Current Zoning: R-8MF(CD) (multifamily residential, conditional)
Proposed Zoning: UR-2(CD) (urban residential, conditional)

Approximately 12.403 acres located on the west side of IBM Drive, south of Baucom Road, and north of University City Boulevard.

The petition proposes a residential community containing a maximum of 200 multi-family dwelling units and any incidental and accessory uses that are allowed in the UR-2 zoning district.

Staff recommends approval of this petition upon resolution of outstanding issues related to environment.

RZ-2

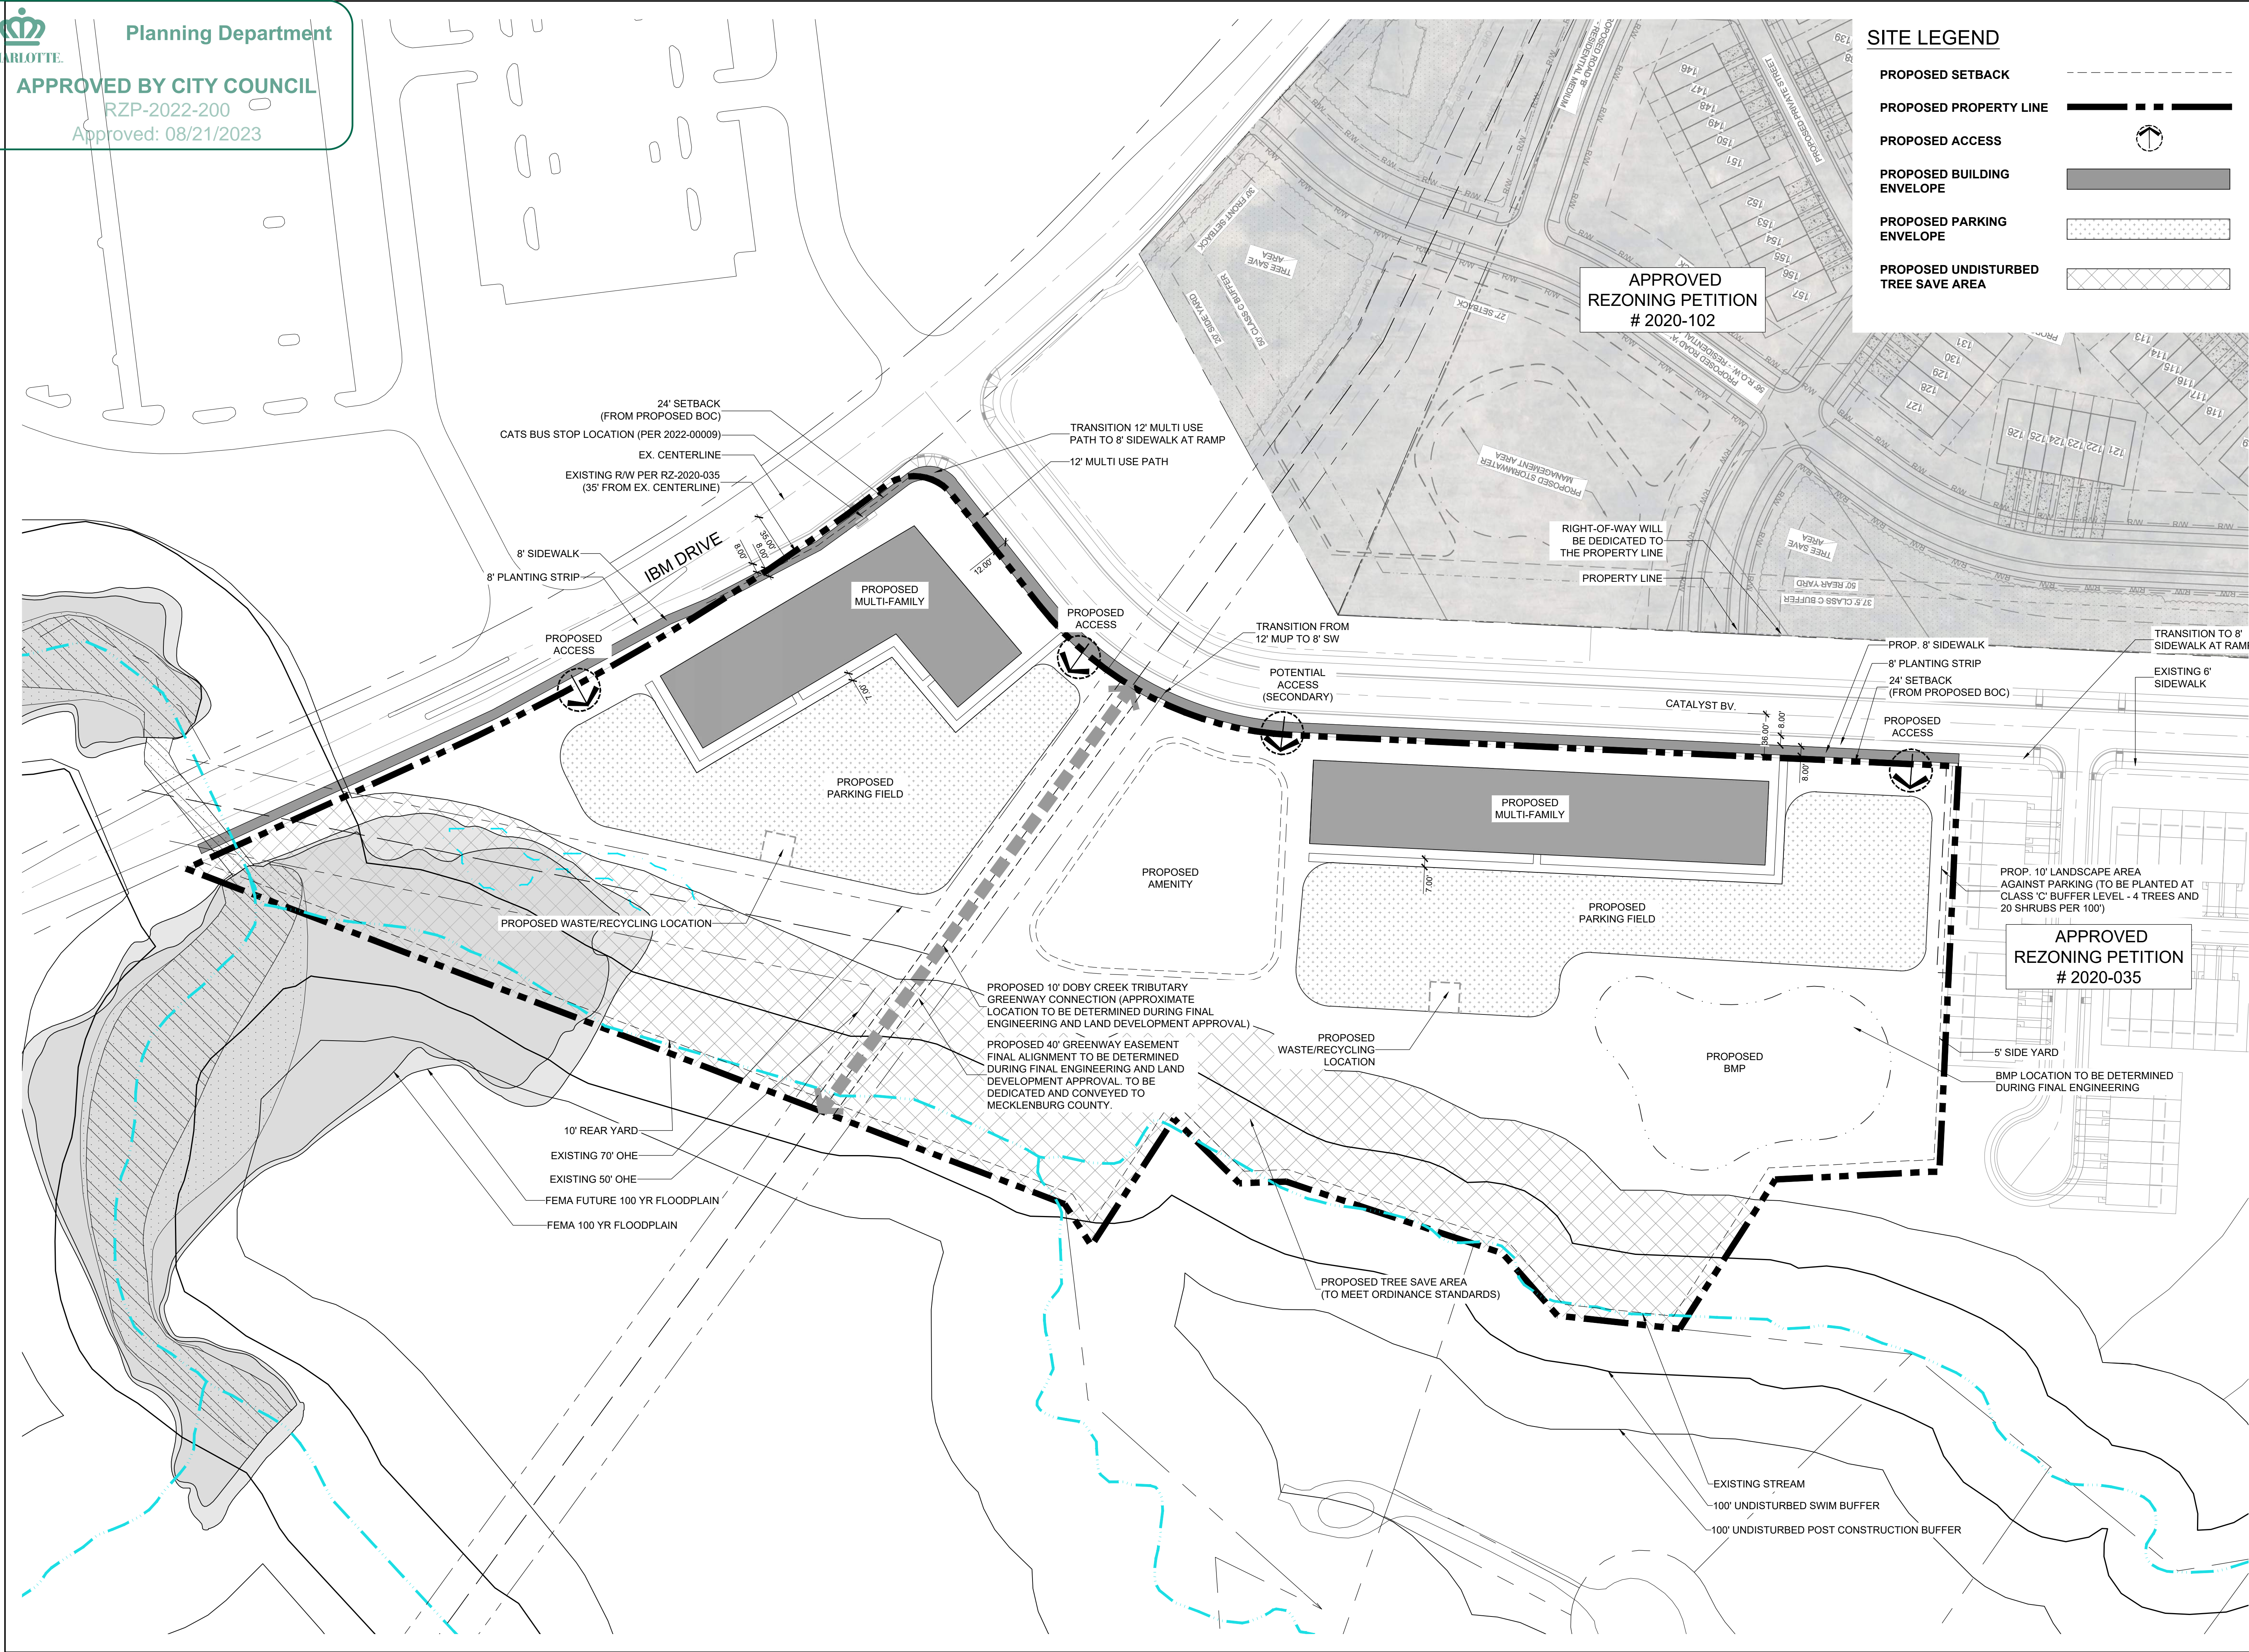
1. ~~Revise site plan and conditional note(s) to commit to revising southern access location to align with the adjacent development access or remove from plan.~~ Addressed

2. Easement note should be revised to read: "dedicated and conveyed to Mecklenburg County".
3. Show tree save area on plans.
